Date: 18/12/2019

Our Ref: 2019/580359

**Visy Dry Recyclables Facility – 112-120 Euston Road Alexandria – SSD 10364**

Area Planning Manager, Major Projects

Figure 2.1. Encroachment into tree protection zones from EIS Aboricultural Assessment

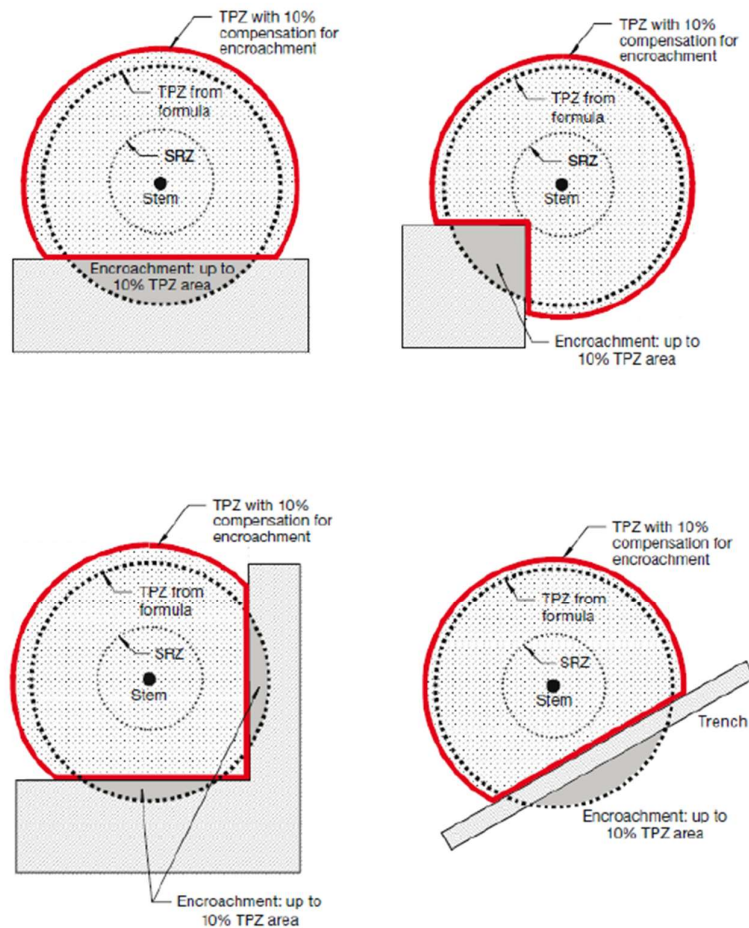
Acknowledging the removal of several trees along Euston Road to accommodate the road widening, the City does not support the removal of the eucalypt from this frontage. While the City appreciates the challenges of accommodating another substation on site, the loss of another tree in this location is unacceptable and in the City's opinion unavoidable. For example, part of the office to the north of the driveway could be demolished to accommodate the substation, or even locate the substation on the driveway. Furthermore, the location and design of the fire hydrant boosters should be further refined to protect the tree protection zone and the streetscape. If this cannot be resolved by the time the Response to Submissions is presented, the City requests the opportunity to liaise further with the developer post consent to reach a suitable outcome.

Figure 2-1 Proposed ground floor layout for Stage 1

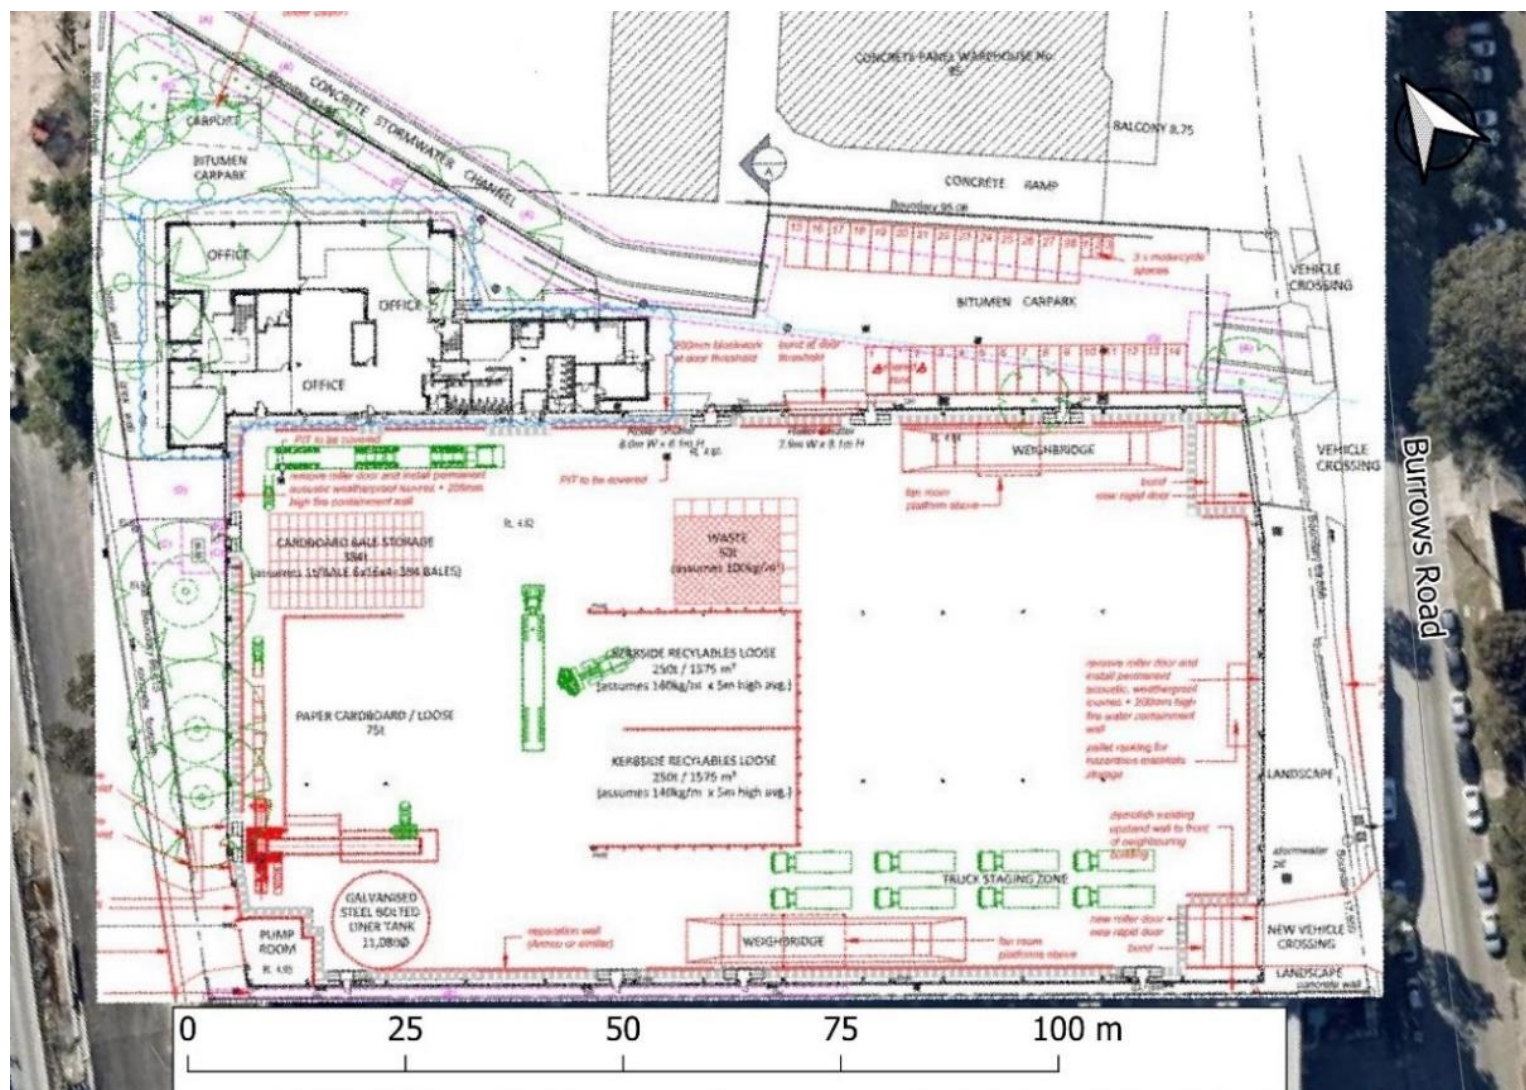
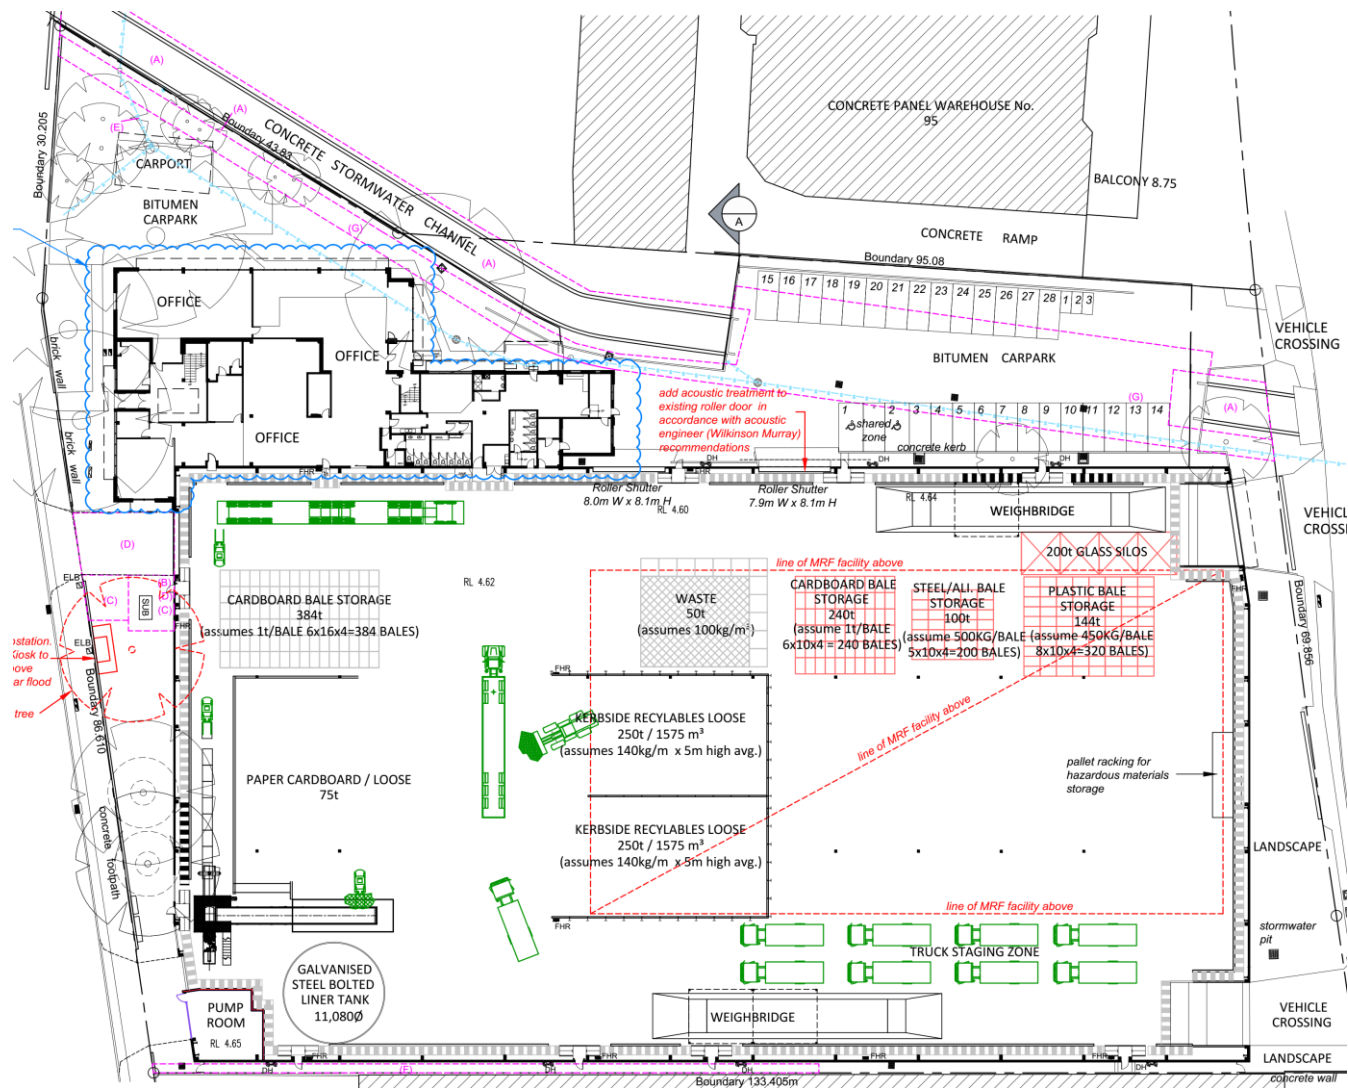
The City accepts that a new driveway is required for the efficient operation of the premises and that the casuarina trees need to be removed accordingly. However, there is an opportunity to increase the canopy between the proposed driveways, particularly through the removal of the existing driveway. We request that plans be provided with the Response to Submissions that the tree canopy in this area can be **doubled** from what is currently present, subject to maintaining acceptable sightlines from the northern driveway and respecting utilities.
